From: [REDACTED]
Sent: Wednesday, November 22, 2023 2:18 PM
To: [REDACTED]
Subject: RE: 3/2023/0812 - Old Row

I am writing on behalf of LNT Care Developments (the applicants) in response to the attached LLFA consultation response to our above planning application seeking discharge of a number of conditions pursuant to the approved Care Home for Older People at Old Row, Whalley Road, Barrow, BB7 9AZ.

In response to comments made regarding Condition 5 please find attached a comprehensive Drainage Strategy (inclusive of already submitted documentation) considerate to all points made in the LLFA response. I will address each point below:-

Impermeable Area Plan

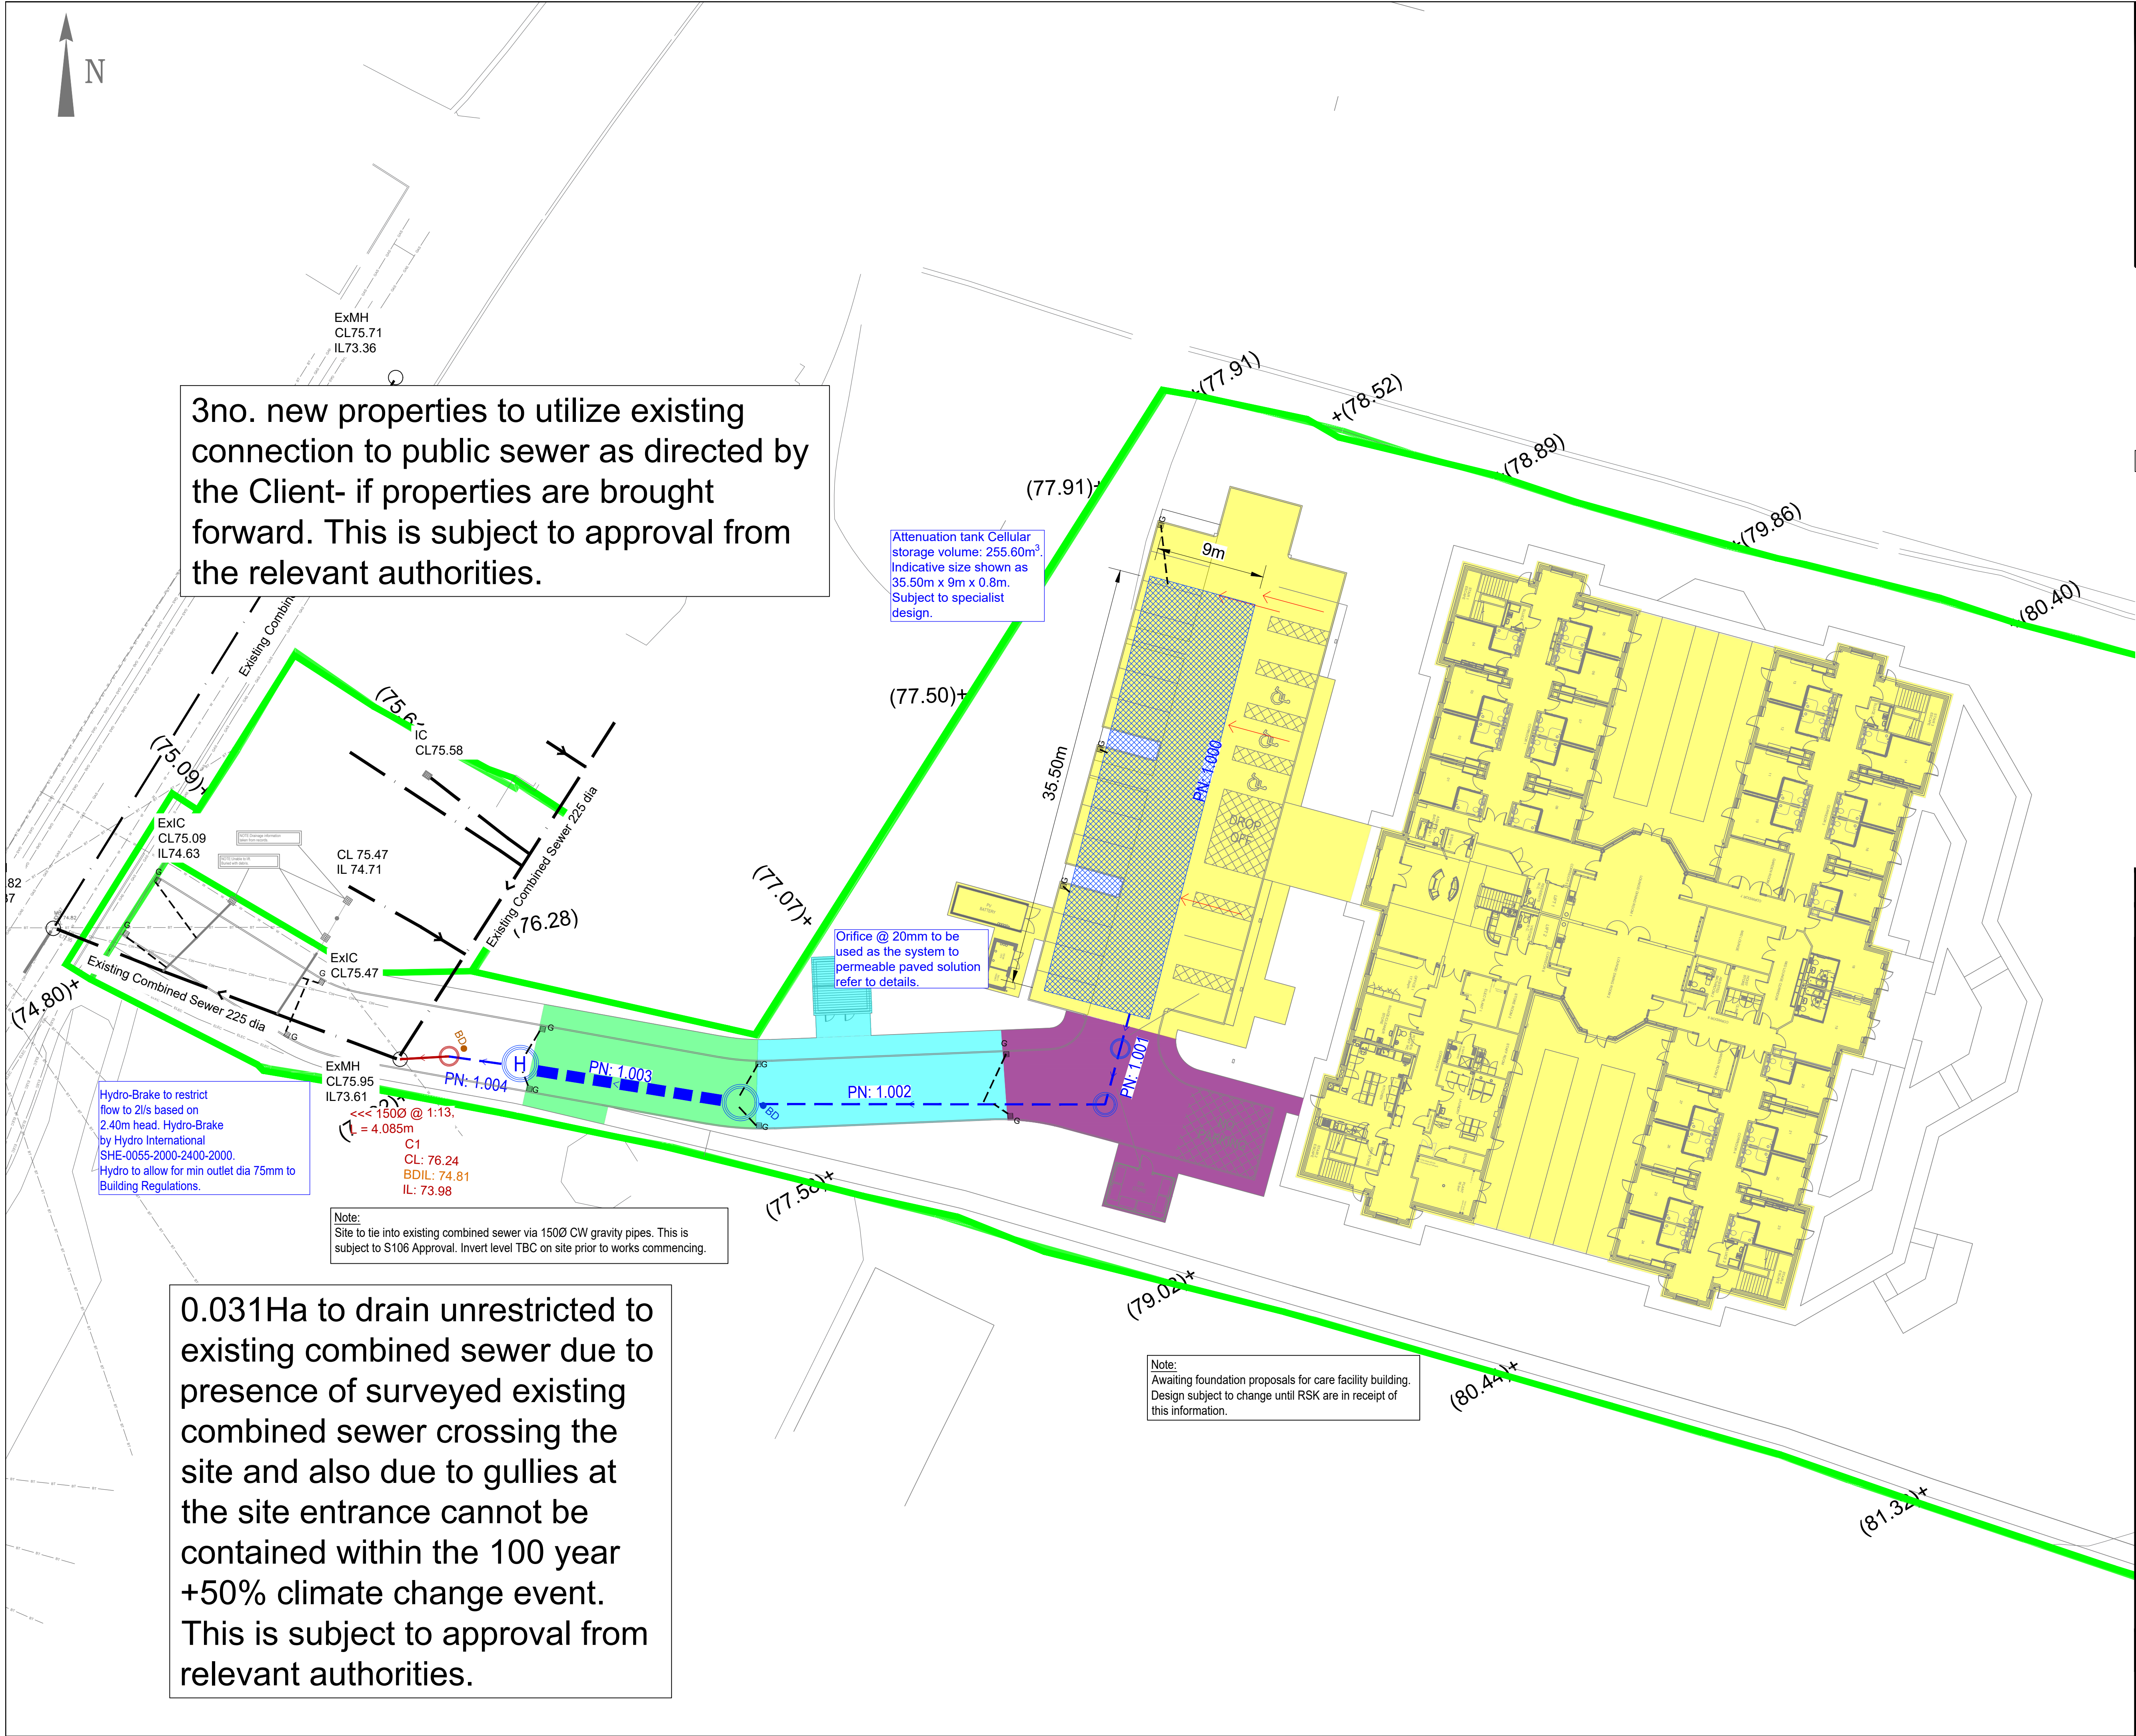
- The applicant has failed to provide evidence of the drainage calculations, along with evidence for an allowance for climate change and urban creep. Please find Microdrainage calculations attached. The impermeable areas plan details the urban creep allowance.

Drainage Layout

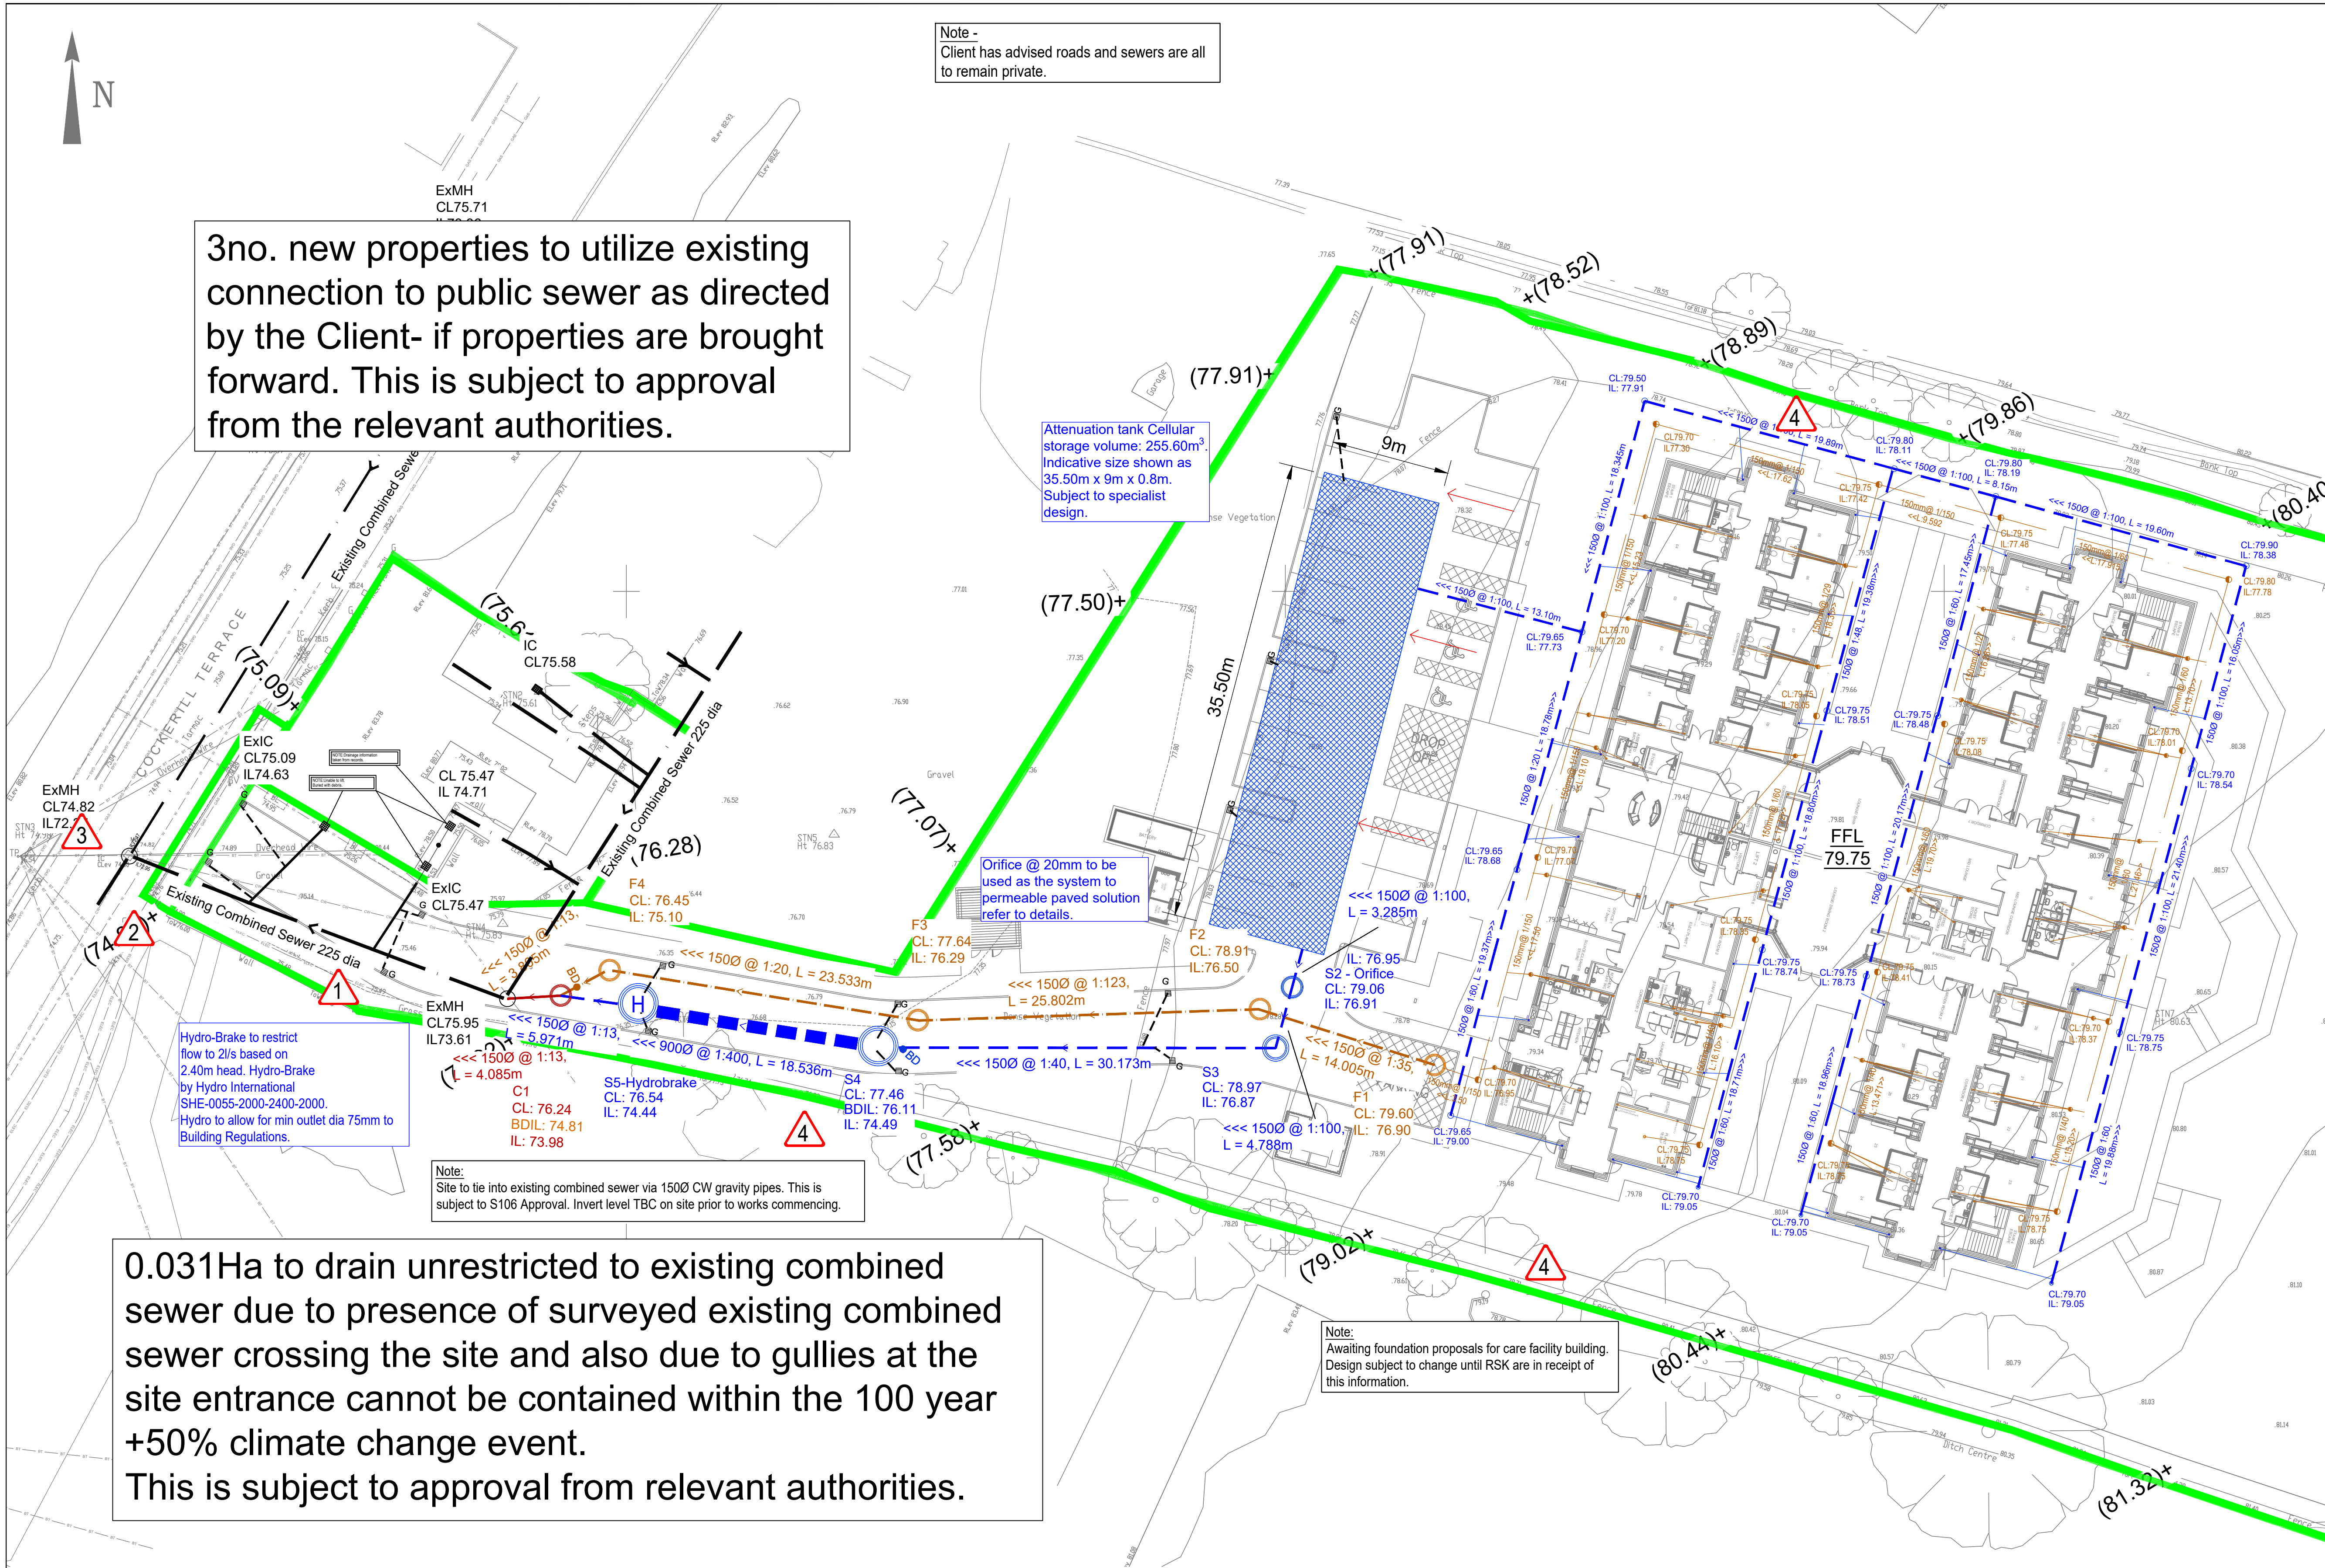
- The applicant has failed to provide evidence of an agreement in principle with the third-party asset owner to connect to the off-site combined sewer. Please find attached the United Utilities response allowing the proposed system to drain to their asset at 2 l/s.
